February 12, 2013

Project Name: Canal Plaza Hotel
Address: 433 Fore Street
Applicant: Cow Plaza Hotel, LLC, Applicant
Planner: Nell Donaldson

Project ID: 2012-558
CBL: 32-I-40

1 EAST ELEVATION
 1/8" = 1'-0"

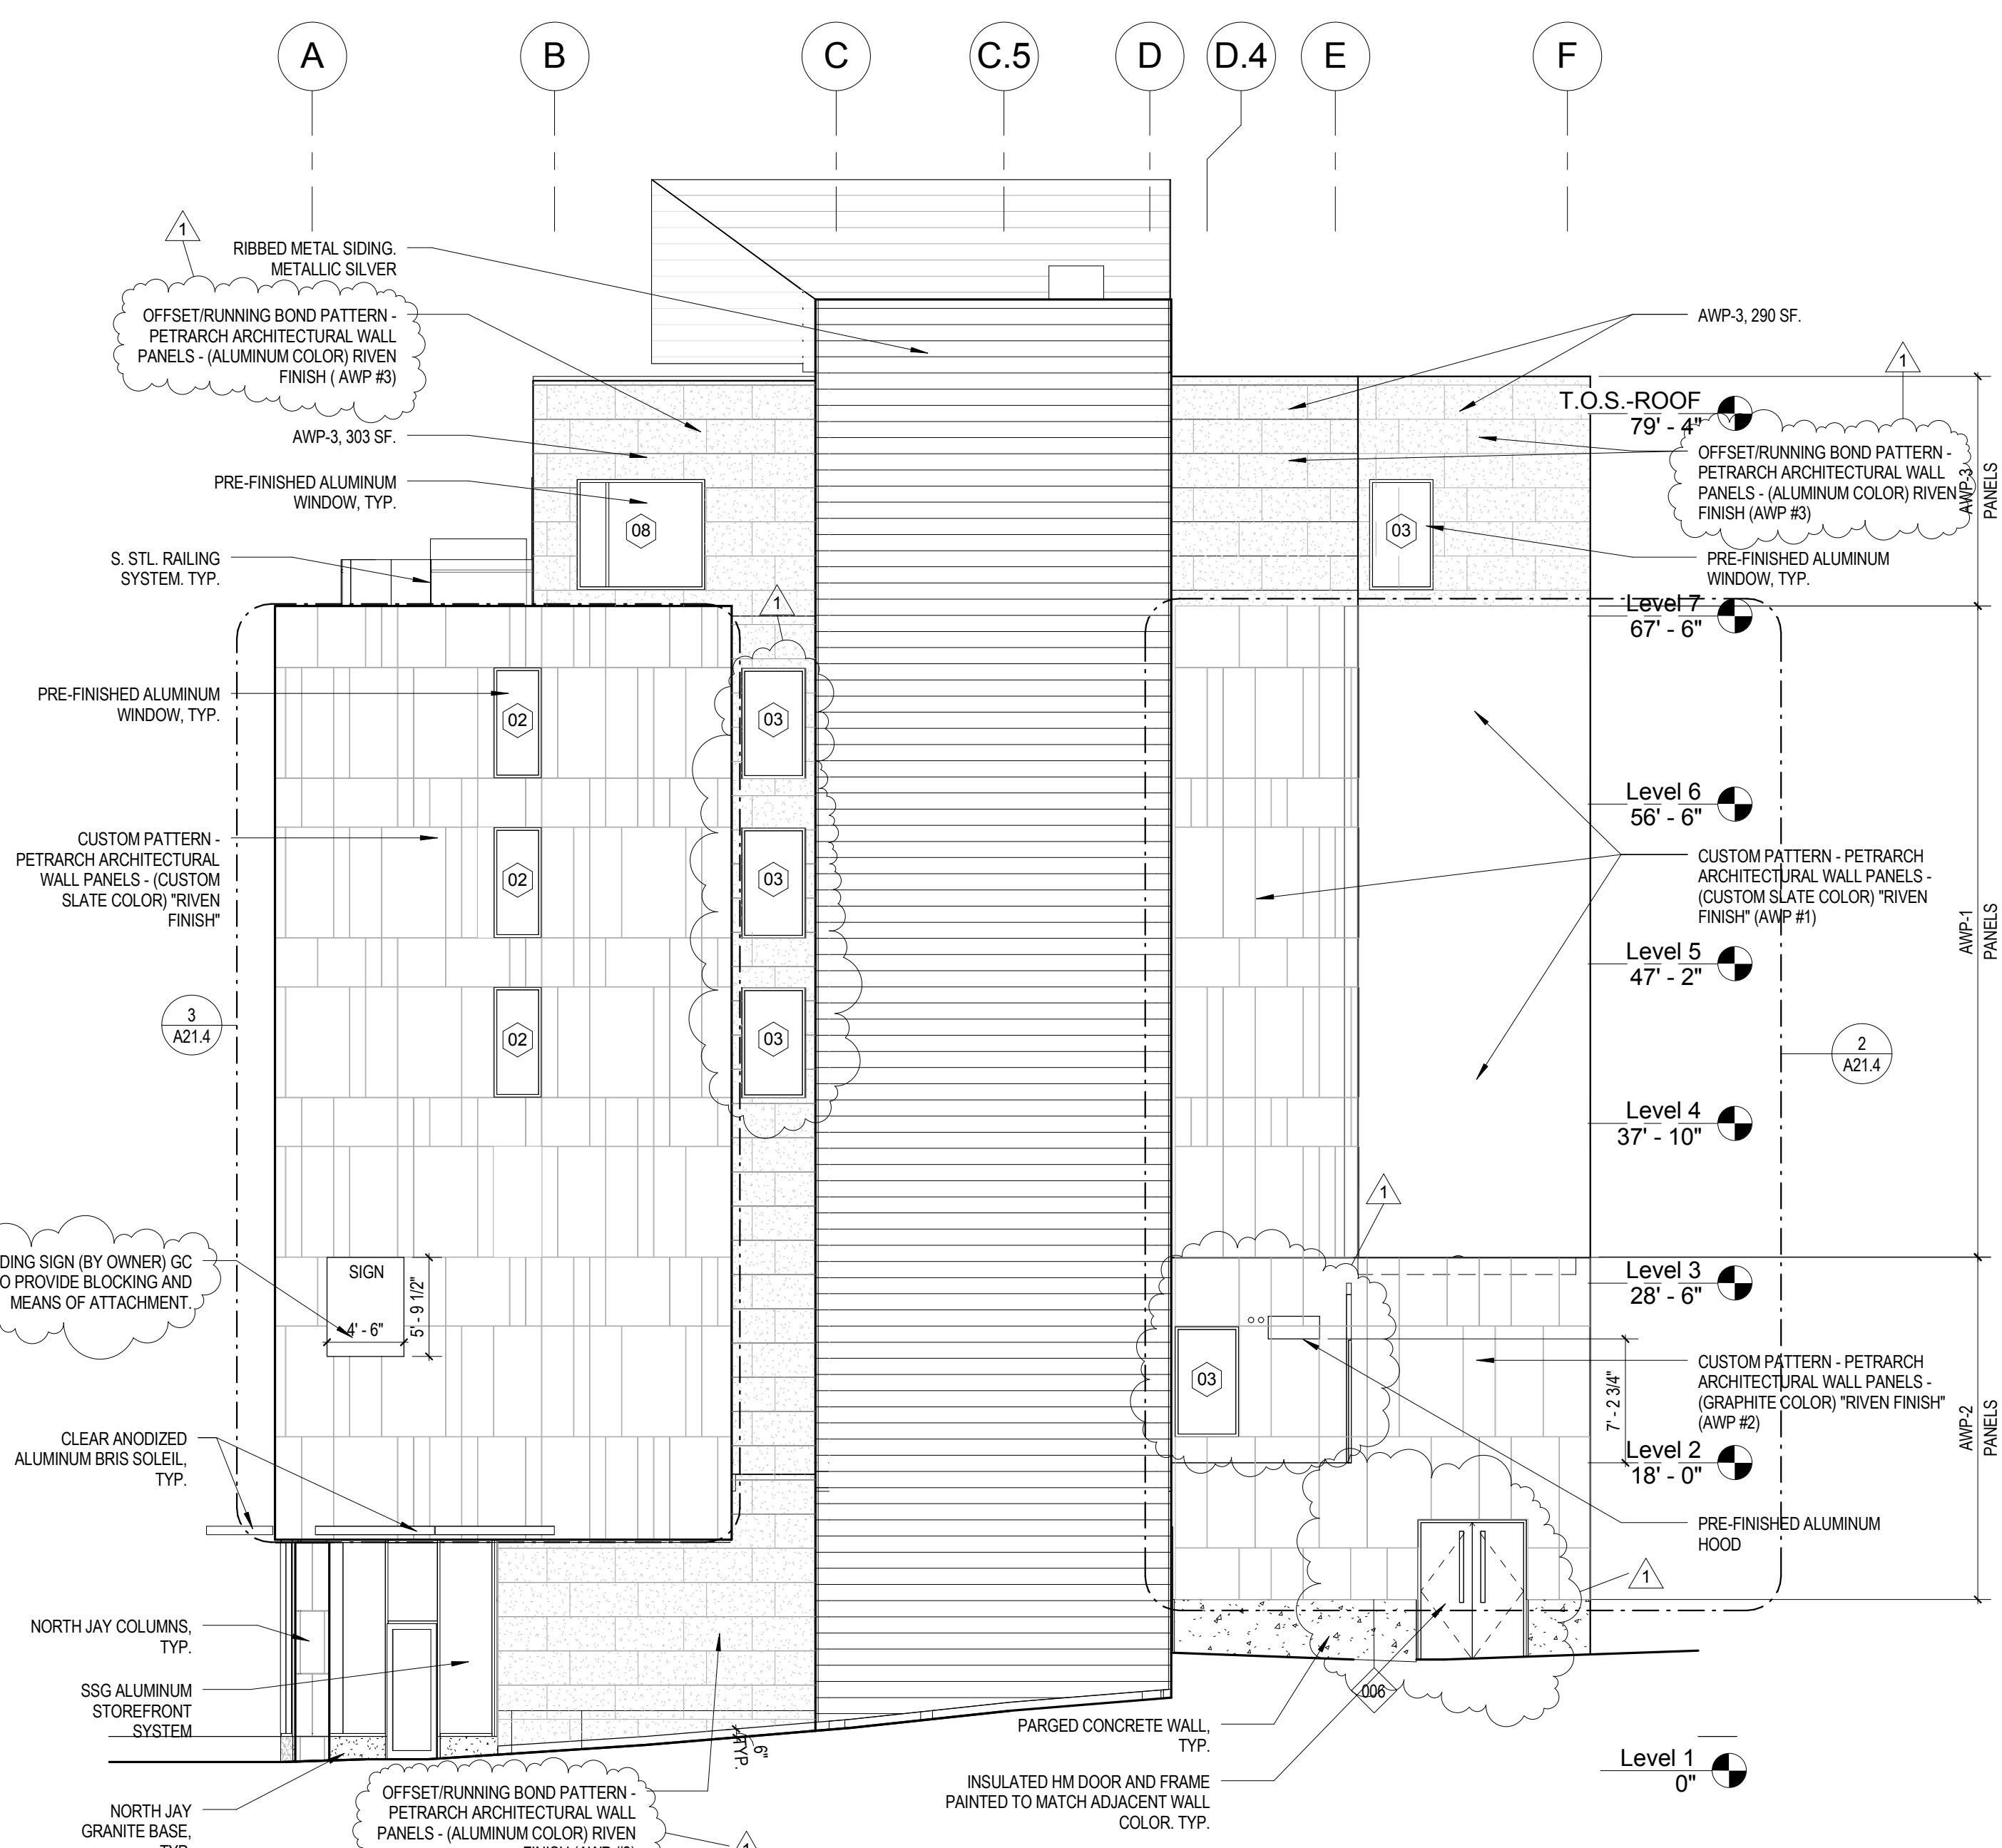
13. The applicant shall submit revised elevations and specifications for the rooftop mechanical screen and stair tower, which address the recommendations of the Planning staff and the Historic Preservation Board, for review and approval by the Planning Authority.

Drawing Title
**EAST AND WEST
 ELEVATIONS**

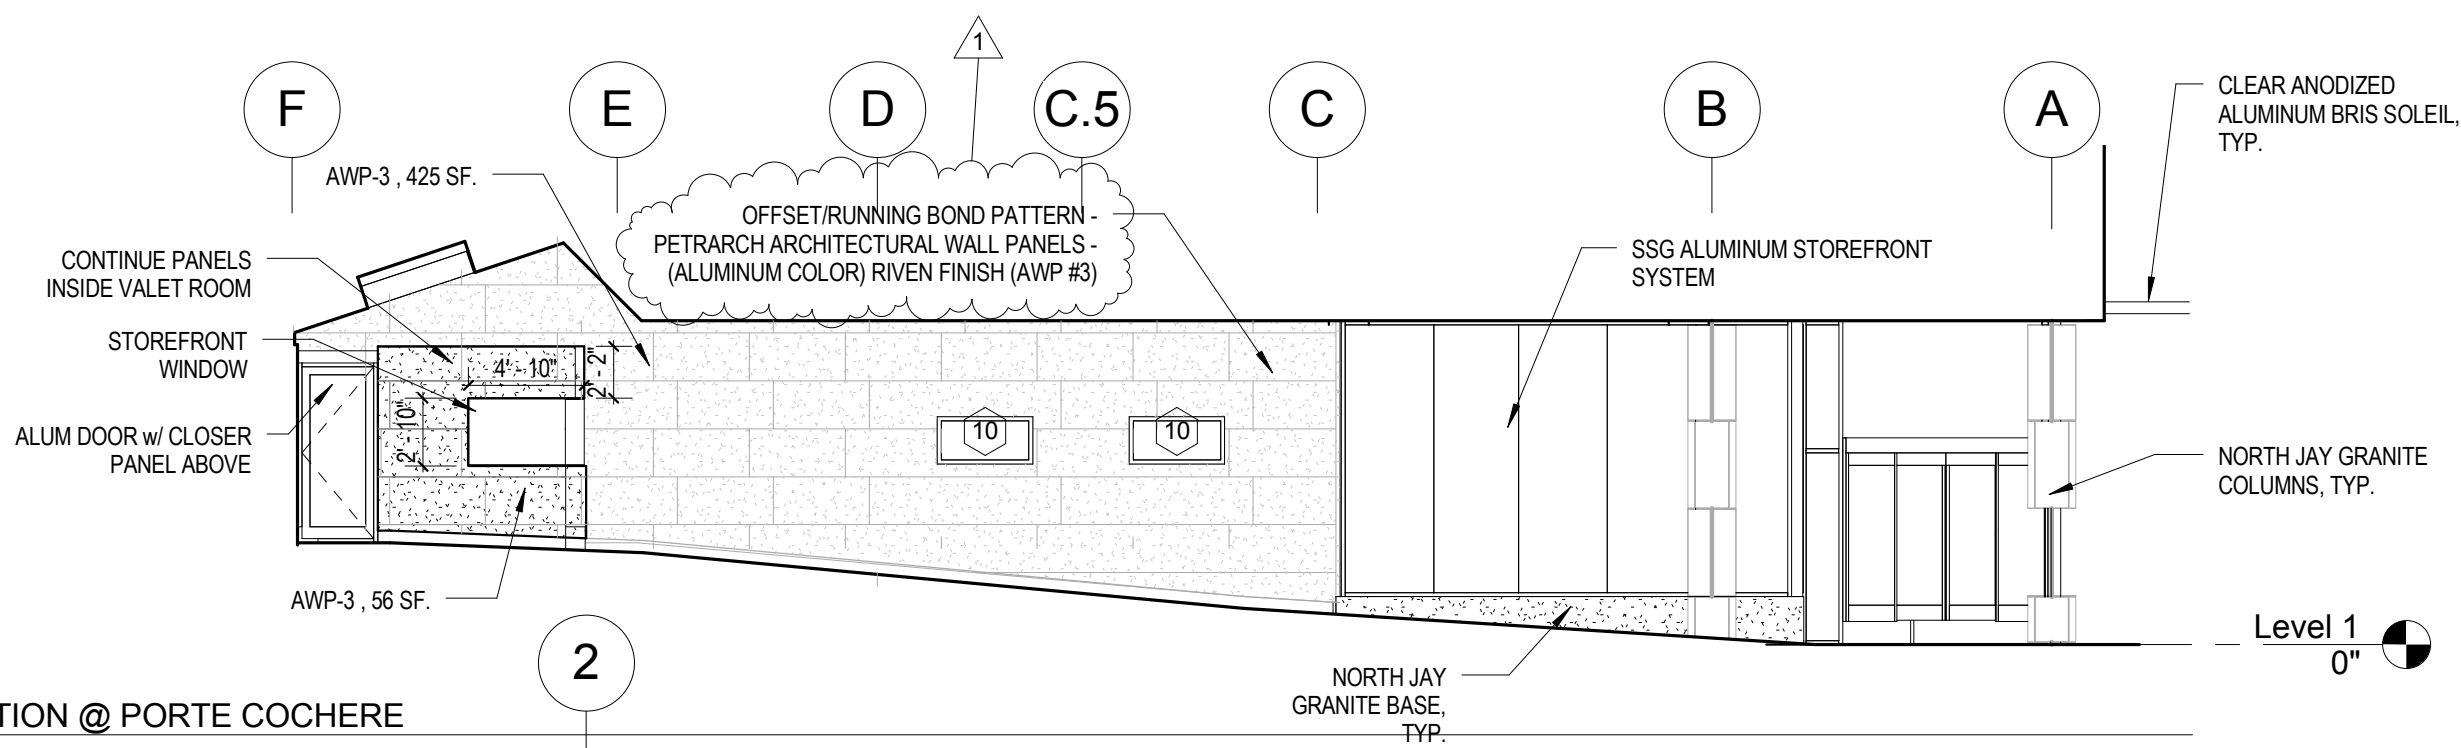
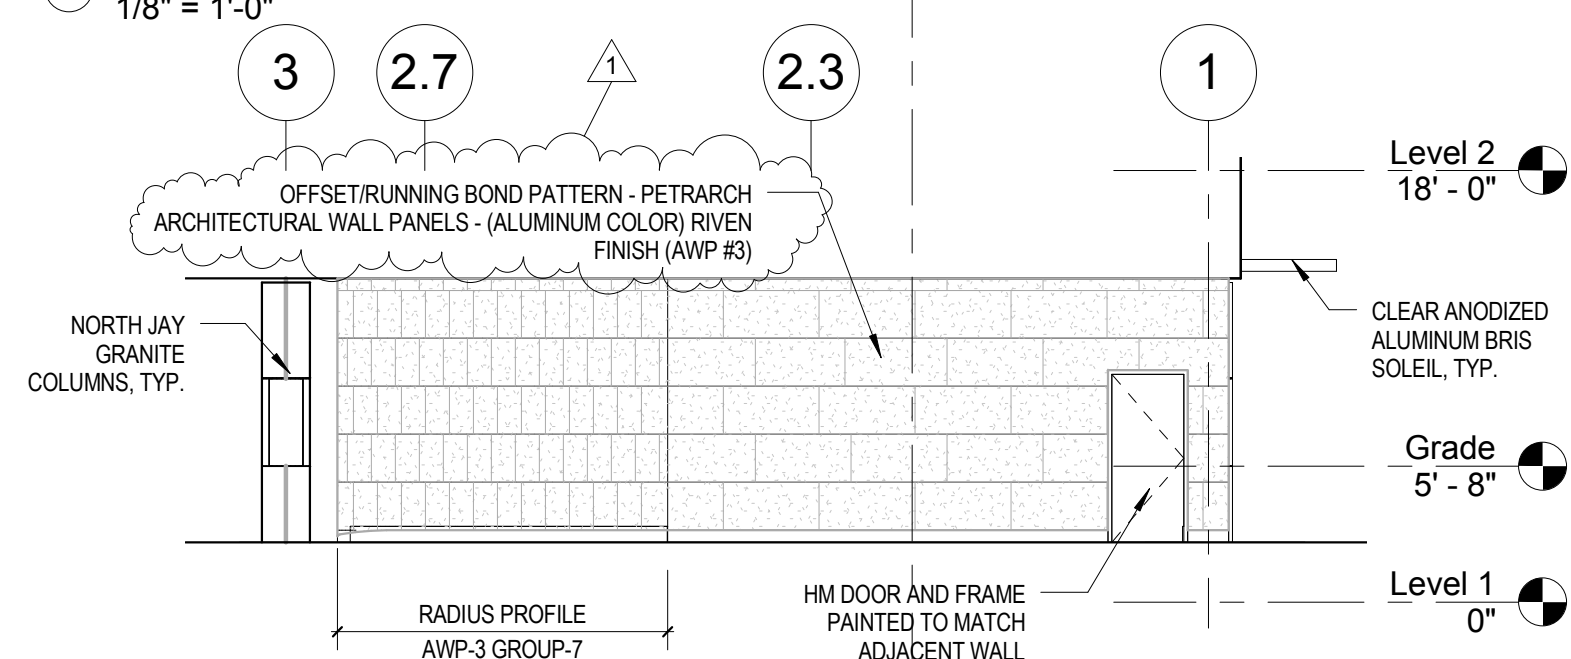
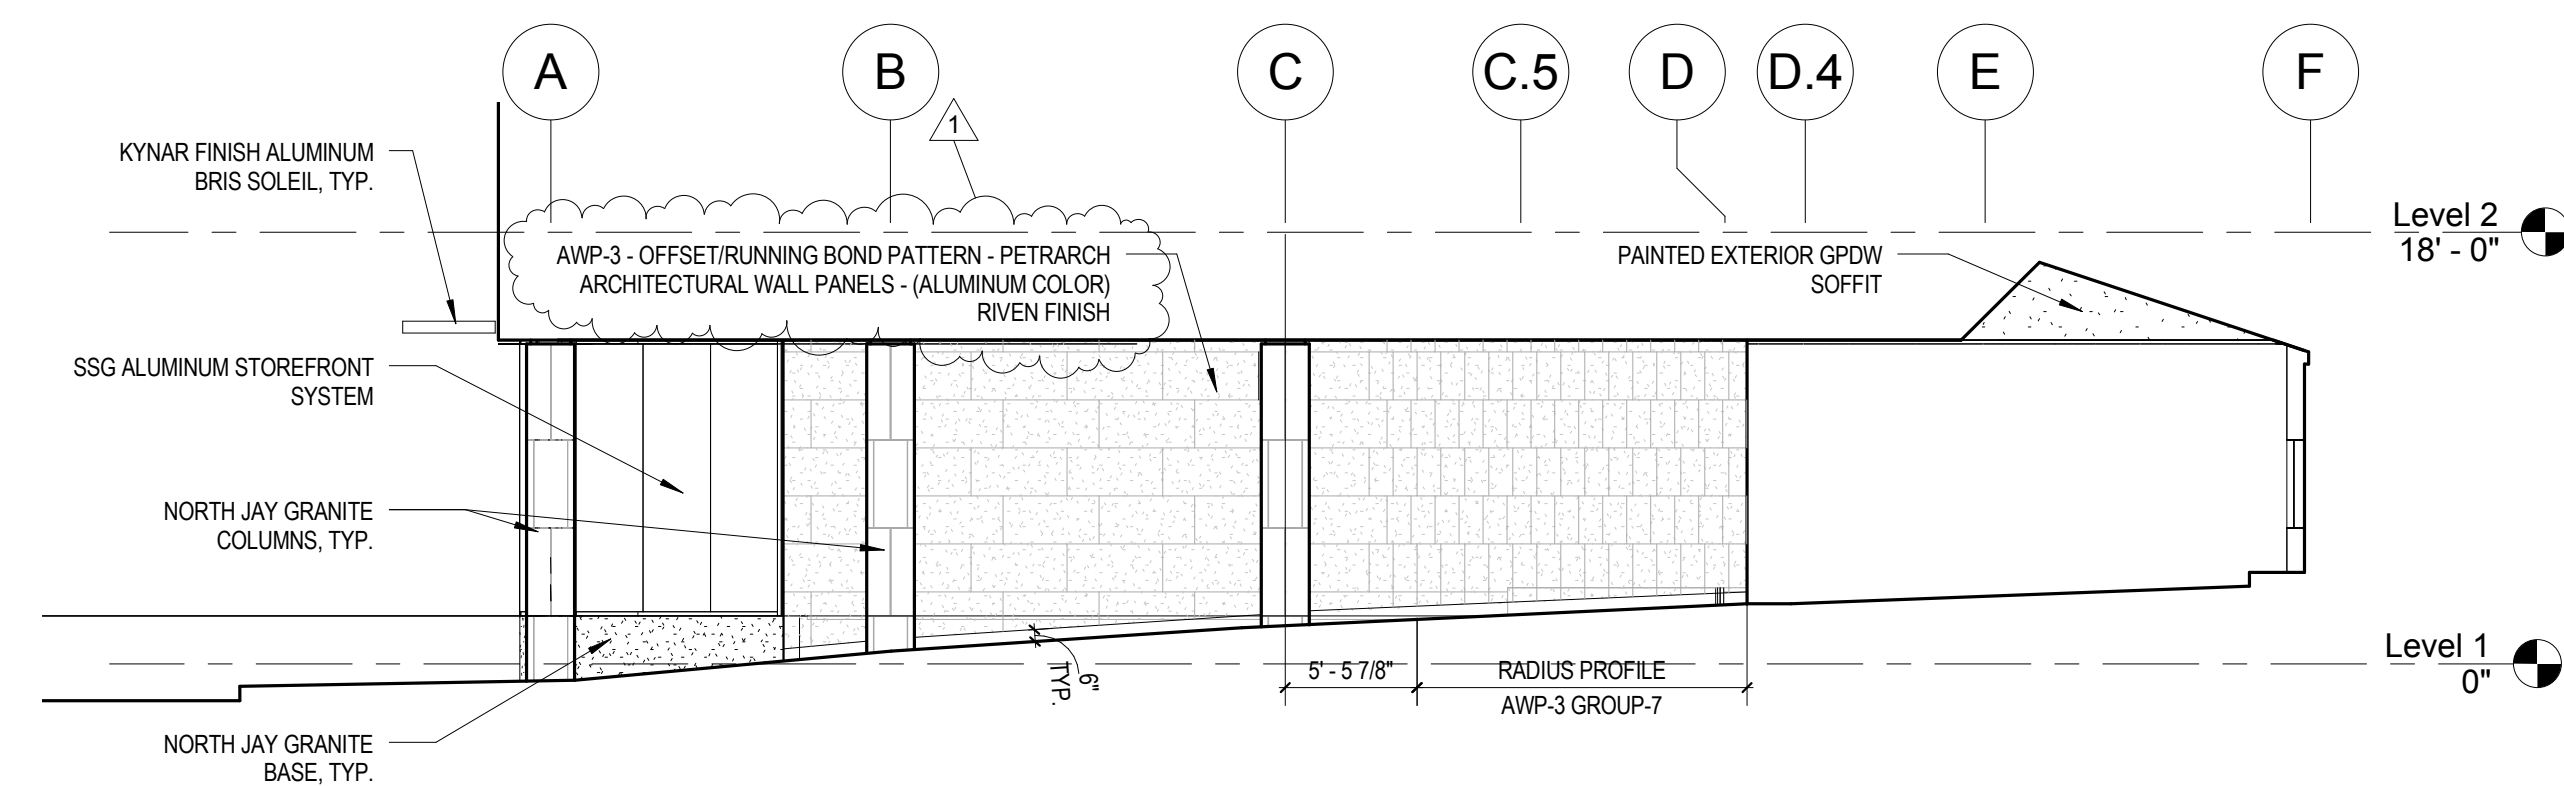
9. The applicant shall increase the clearance in the porte cochere to 10', for review and approval by the city's Fire Prevention Bureau;
10. A final lighting plan including photometric data and meeting relevant Technical Standards, which may include any proposed low intensity top floor wash or grazing lighting, shall be
